**From:** Joe Gilbert  
**Sent:** Tuesday, April 30, 2013 8:15 AM  
**To:** Jeff Watson  
**Subject:** RE: soil log, Barnes short plat

**From:** Betty Barnes [<mailto:barnesinc@elltel.net>]  
**Sent:** Monday, April 29, 2013 12:49 PM  
**To:** Joe Gilbert  
**Cc:** 'Dustin Pierce'  
**Subject:** soil log, Barnes short plat

SHORT PLAT
 PREPARED FOR
 BETTY BARNES
 A PORTION OF THE NE 1/4 OF SECTION 5,
 TOWNSHIP 16 NORTH, RANGE 20 EAST, W.M.,
 KITTITAS COUNTY, WASHINGTON.

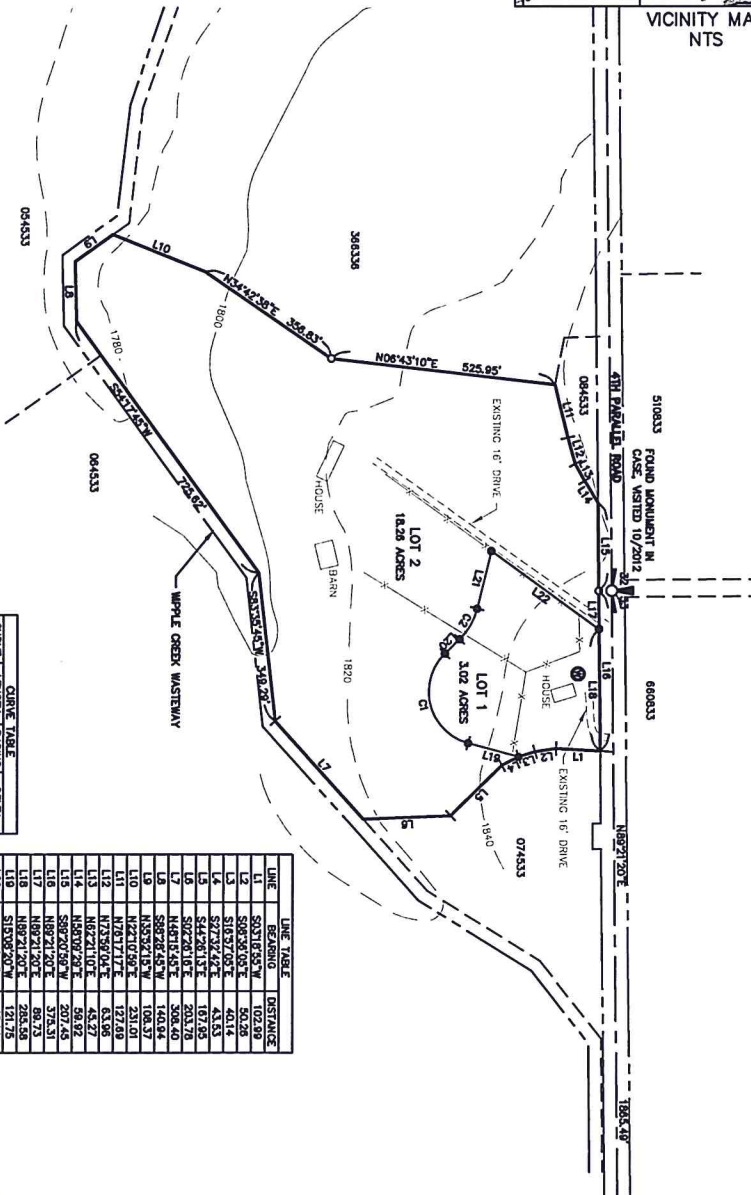
YES, THE PRELIMINARY PLAT MAP DOES NOT SHOW THE OTER WELL HEAD EMCOMPASS IS GOING TO HAVE IT ON FINAL MYLARS. I HAVE NOTED IN MY FILE. THANKS.

That is boiler plate comment language, your type of plat is not common, since both lots have septic systems already existing on both lots, then soil logs are not required. Also we spoke to your surveyor a couple weeks ago regarding locating the other well head on the final mylars. Your health dept. requirements will be met once I see the well head located. Thanks
